Richard Boyd Barrett T.D.,
People Before Profit,
Leinster House,
Kildare Street,
Dublin 2,

28 October 2022

Re *DART* West Planning Application

Ref: 314232

STATIONS DESIGN SPENCER DOCK STATION STATION LOCATION

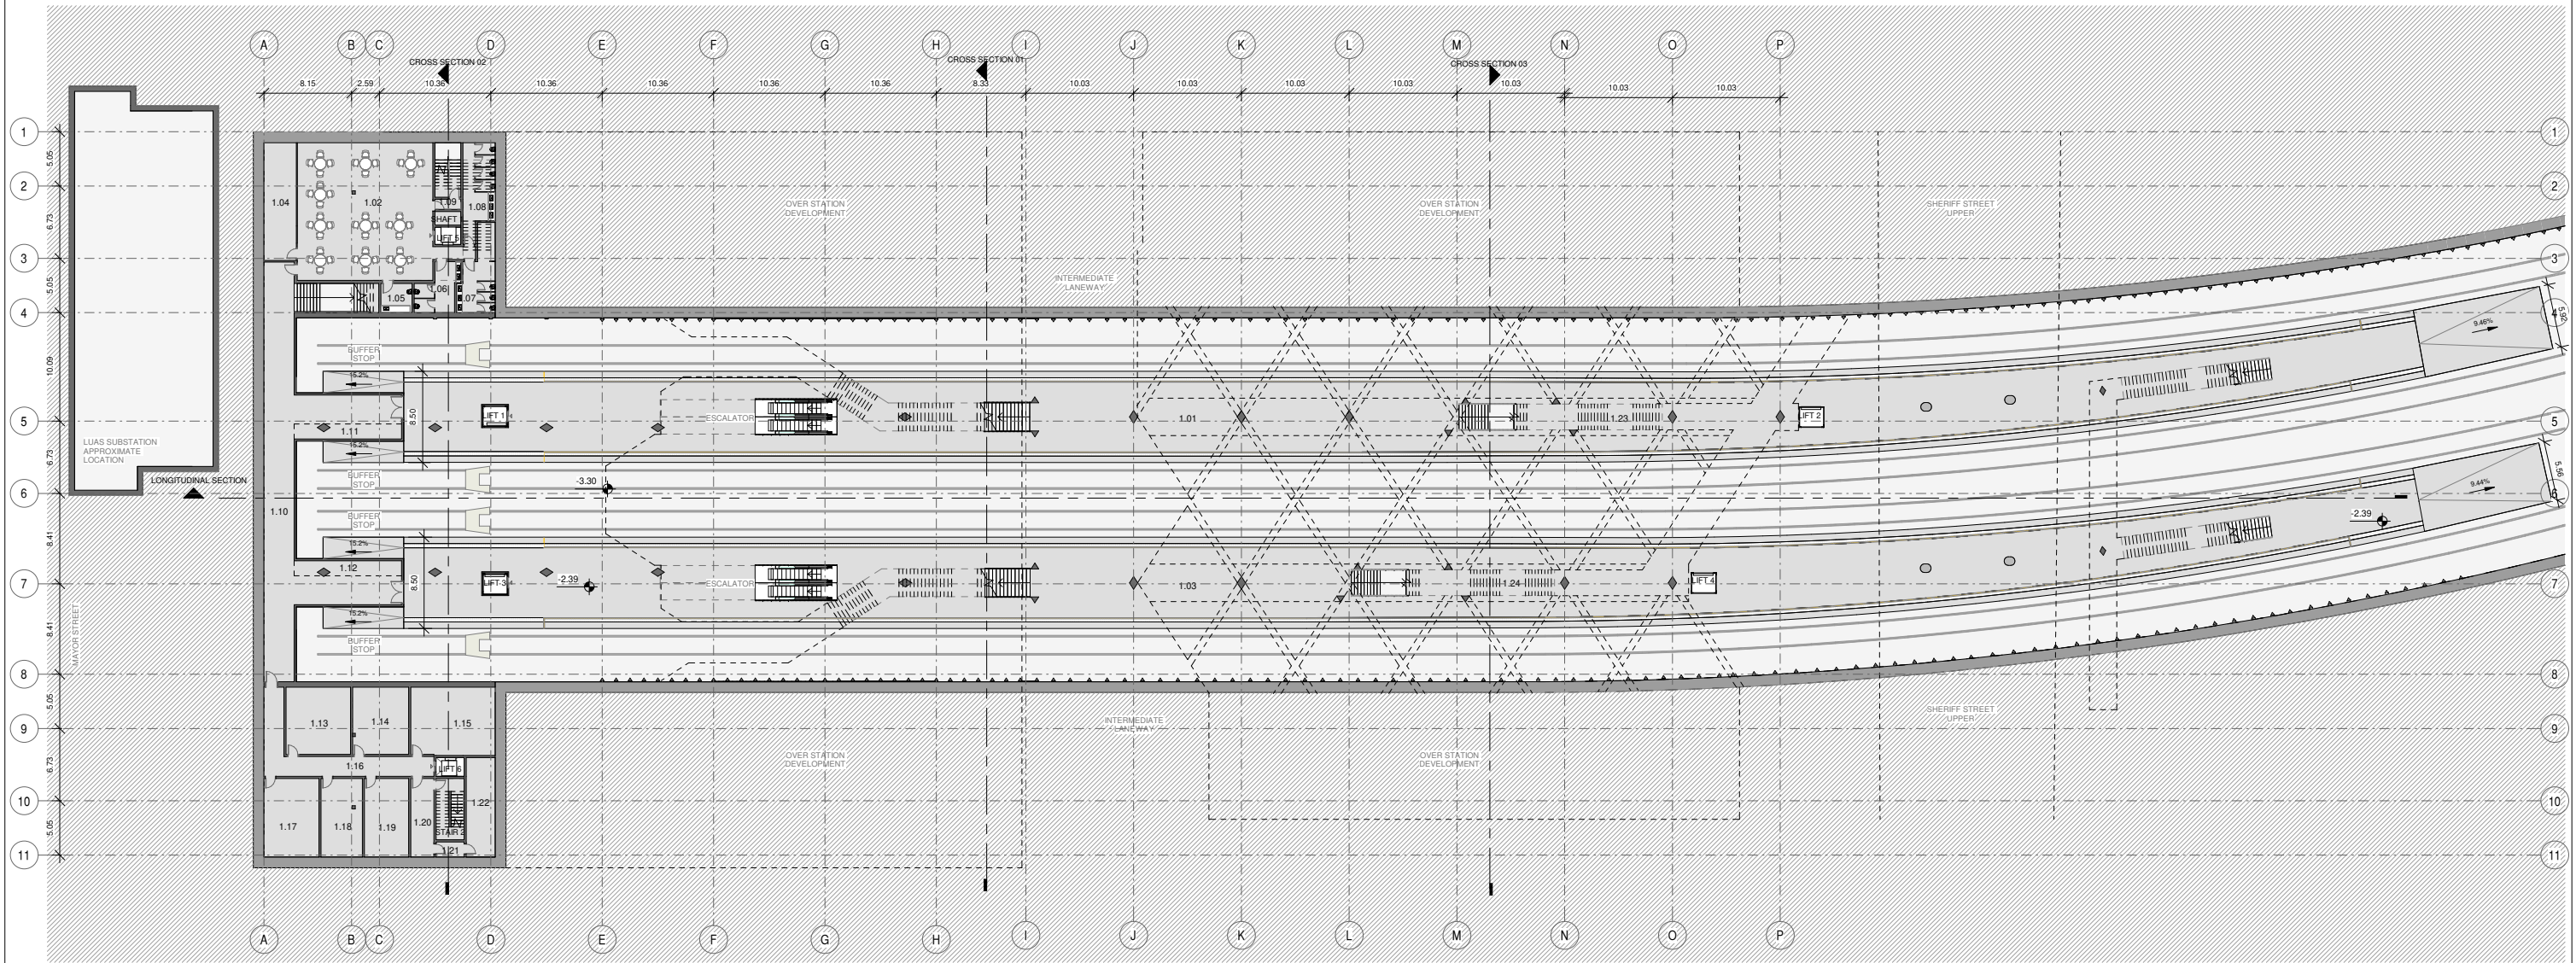
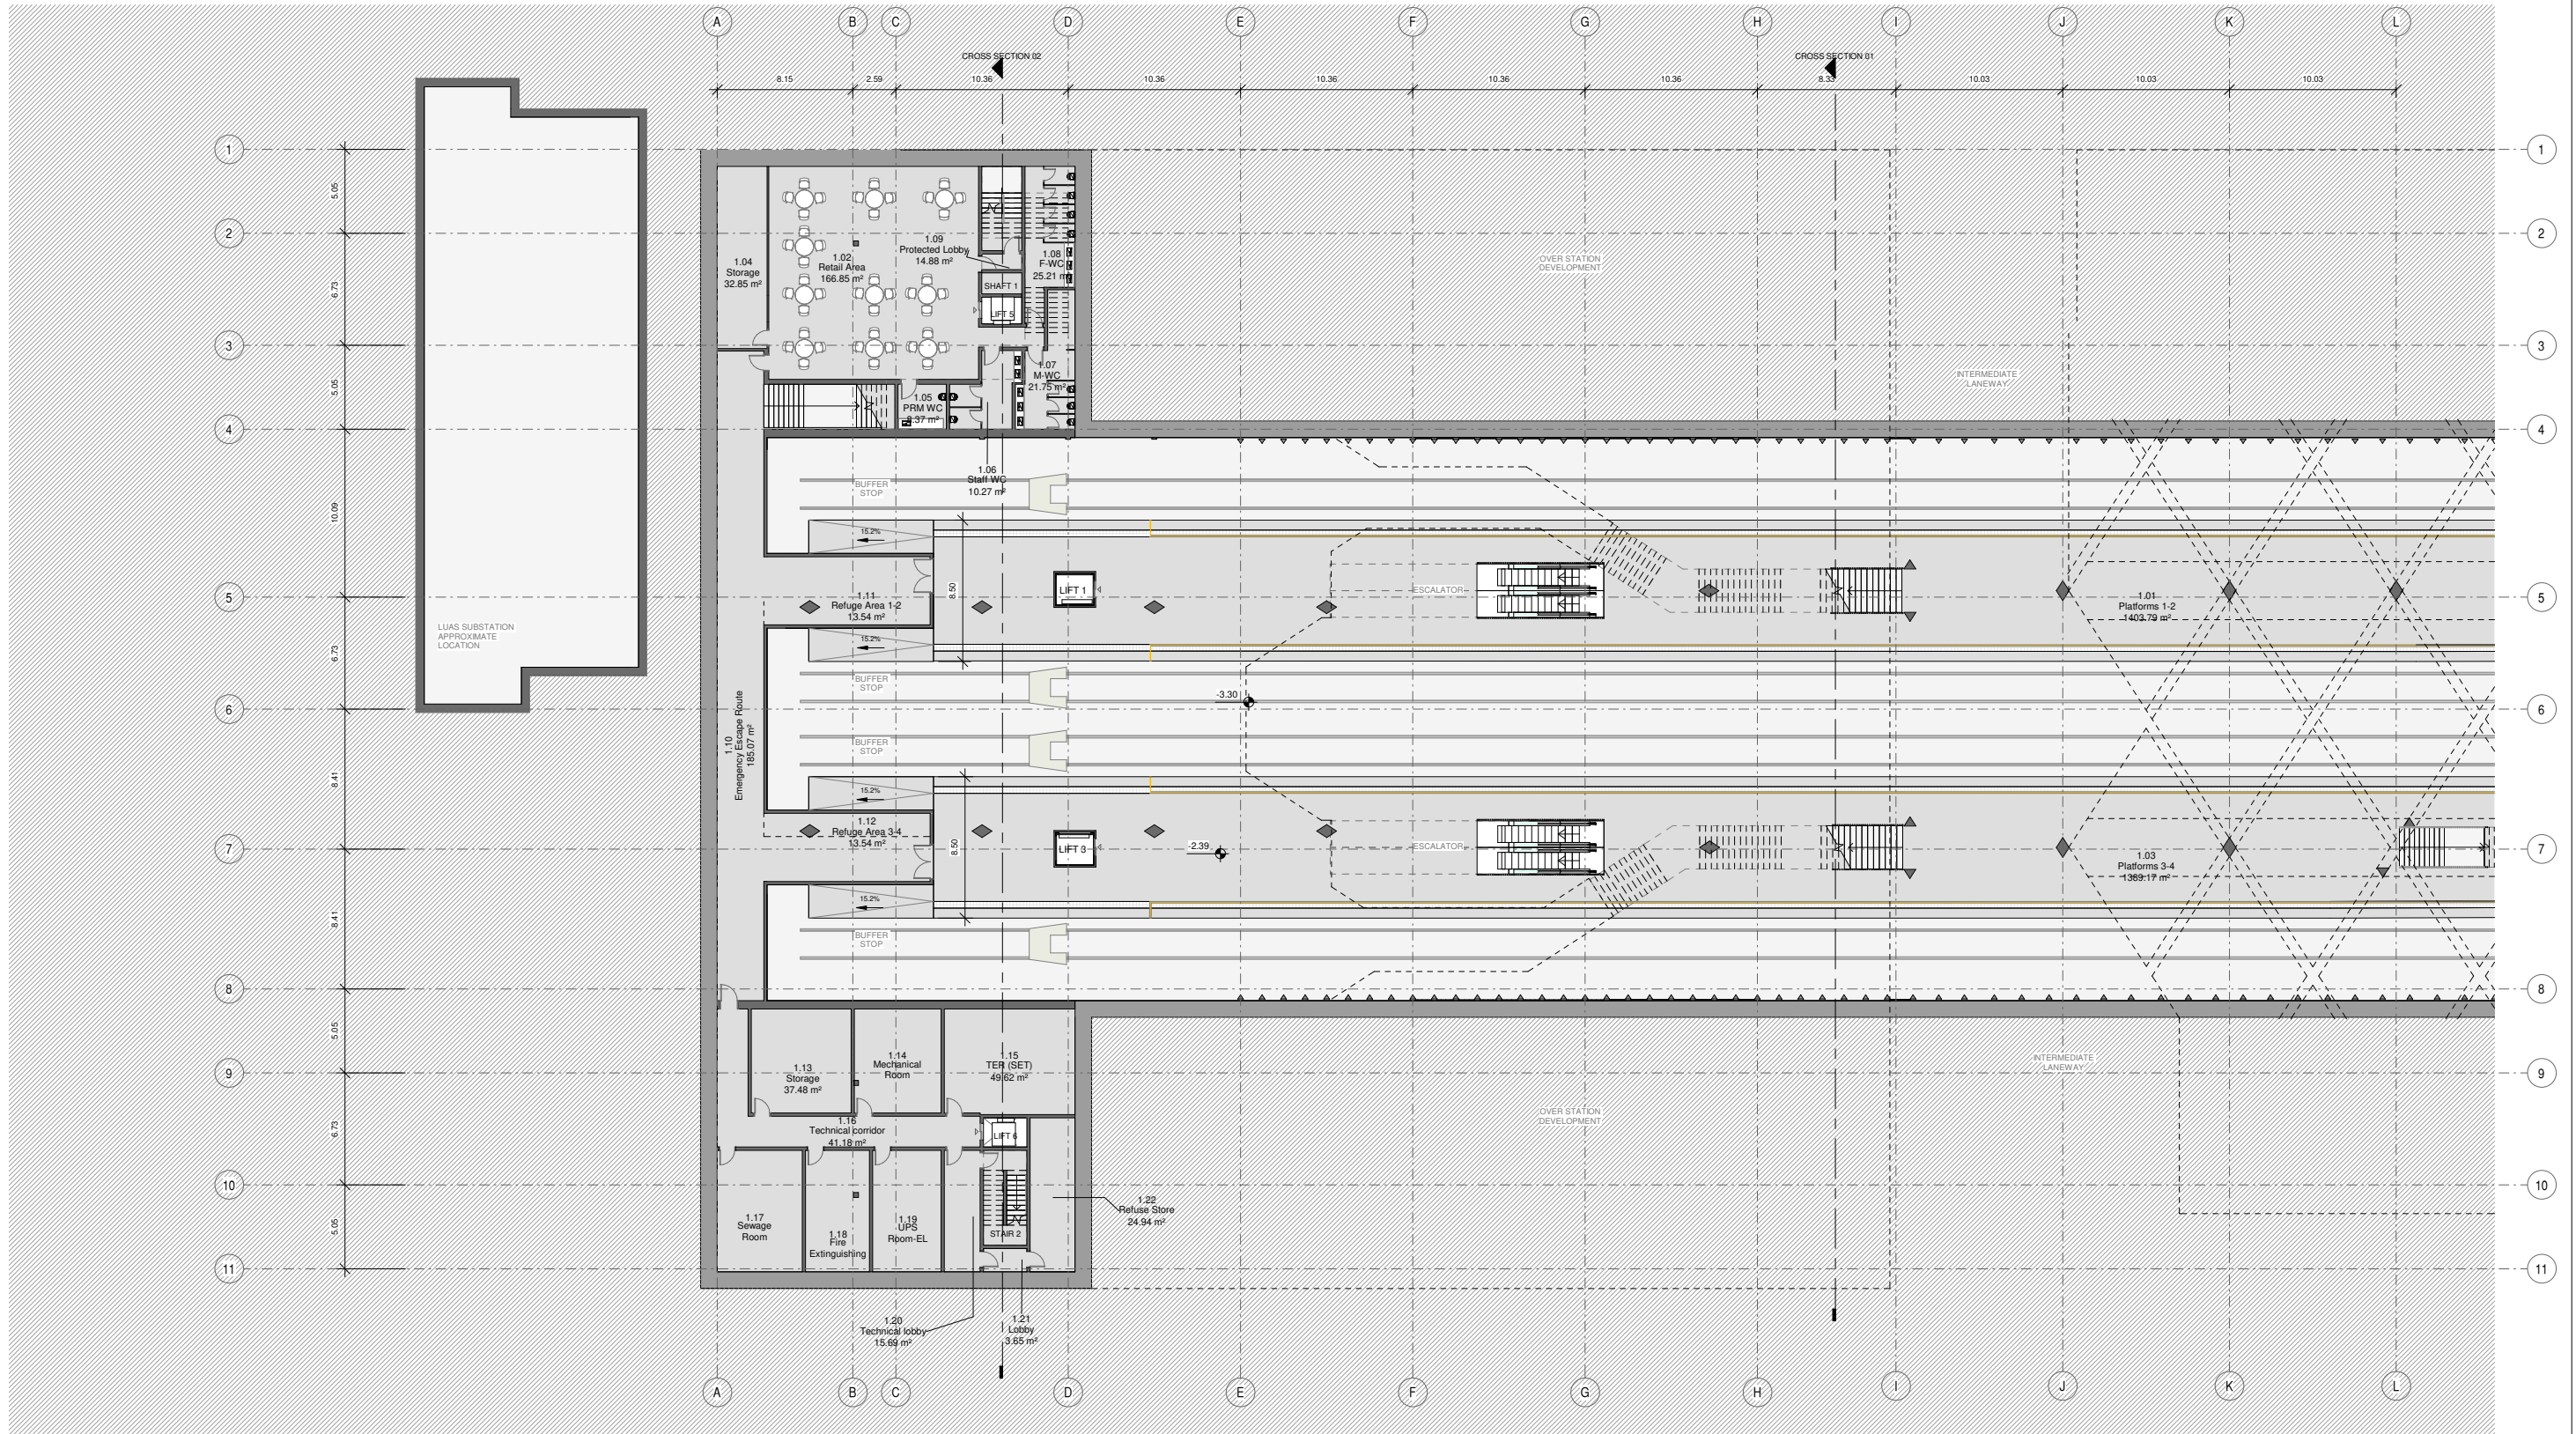
According to media reports €100 million may be needed for the plan by Irish Rail to develop a new underground station at Spencer Dock. This is an enormous cost, from which there seems to be very little immediate benefit. Ultimately the station may be useful if the *DART Underground* tunnel is built – yet that is not currently happening.

As this development would be underground it costs many times more than a station built overground – and is also exposed to a lot more risk in terms of the project encountering unforeseen difficulties that are then more expensive to resolve.

Hence this element of the scheme should be deferred – and that this capital instead be spent on stations that need to be opened, such as at Croke Park, Phibsborough etc.
